Boys & Girls Club Administrative Conditional Use File Number ACU-25-00002 FINDINGS OF FACT, DECISION AND CONDITIONS OF APPROVAL

Requested Action: The applicants are proposing an addition to an existing building and the establishment of a Boys & Girls Club. The property is zoned Rural 5 with Rural Residential land use.

Date: November 4, 2025

SEPTIC SITE PLAN

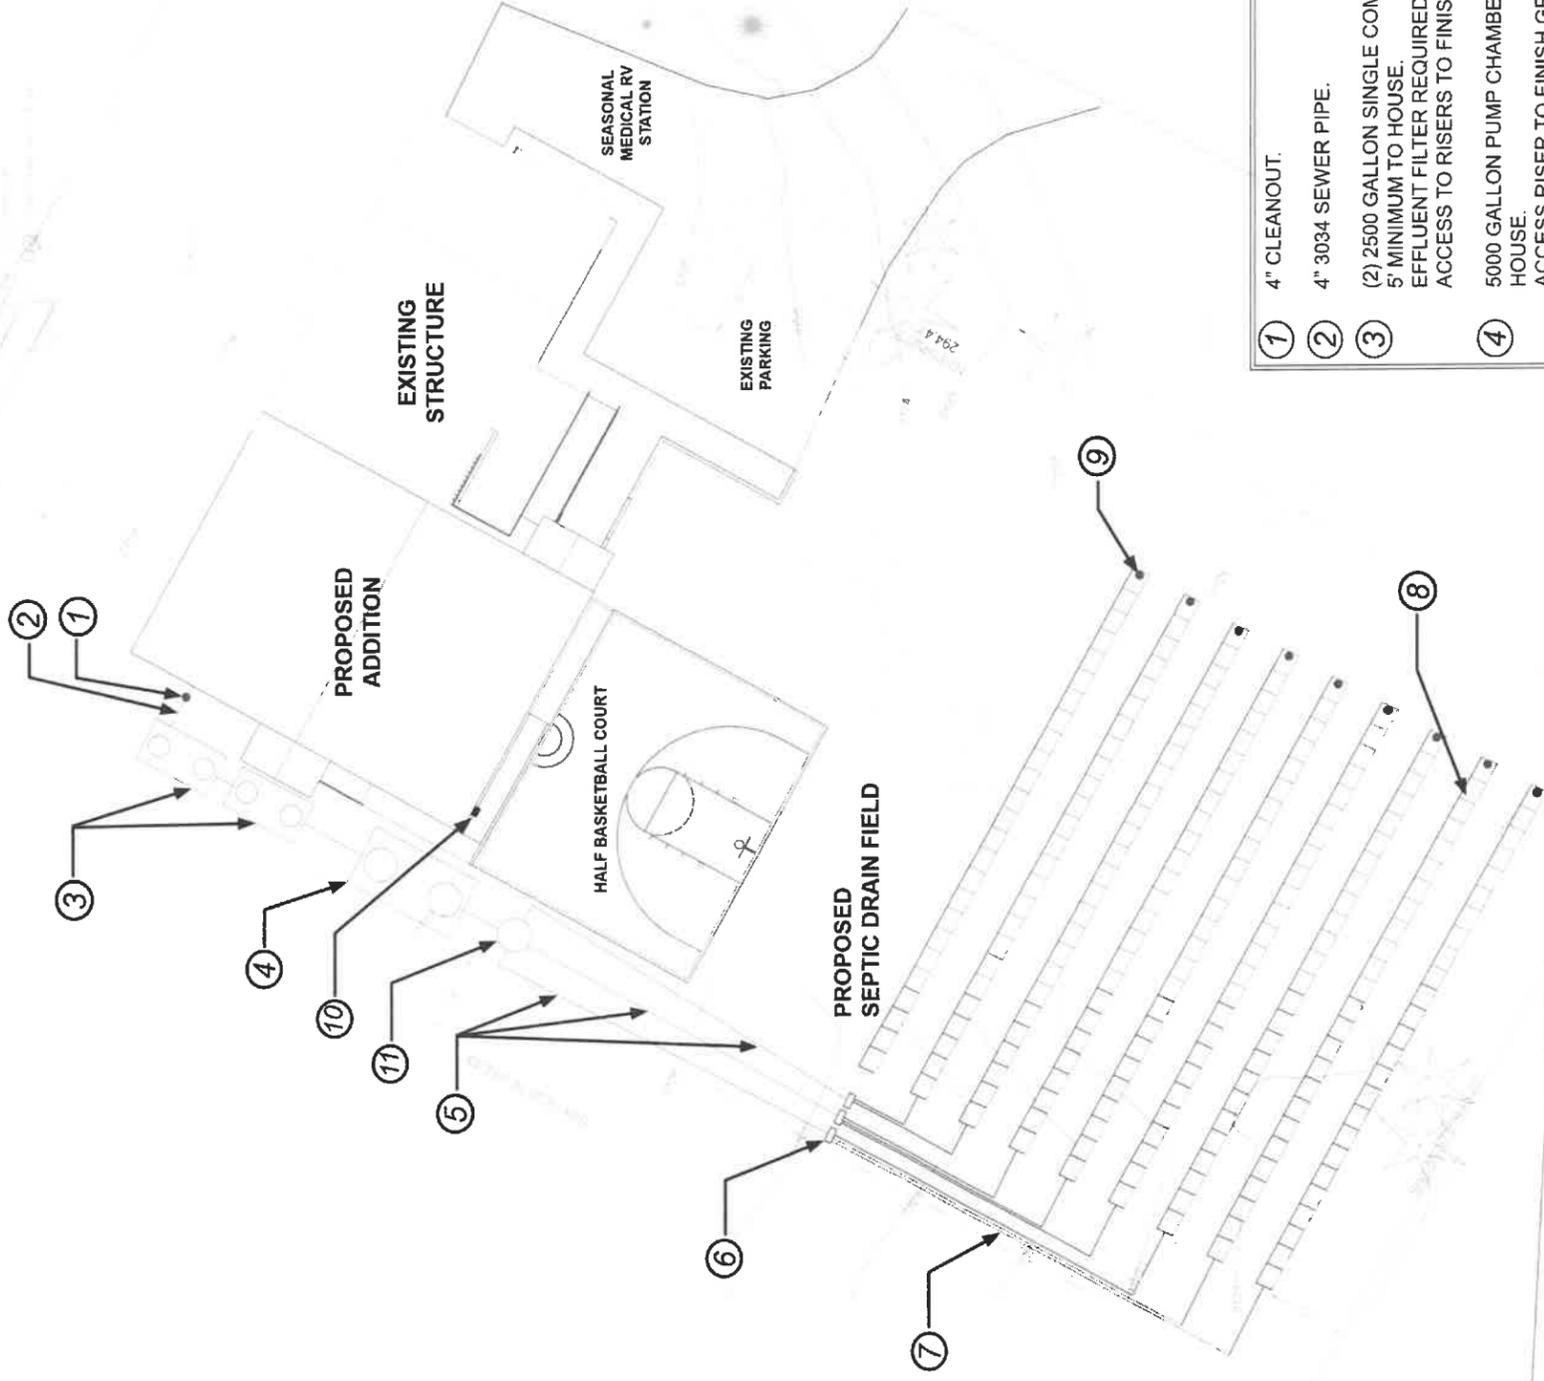
- As the proposed site plan does not show property boundary lines, and the development proposal appears to be quite tight to fit on the existing property, applicants are reminded that they must adhere to setback requirements. It is strongly recommended a land surveyor be utilized to ensure that the proposal does not encroach or trespass onto adjacent parcels.
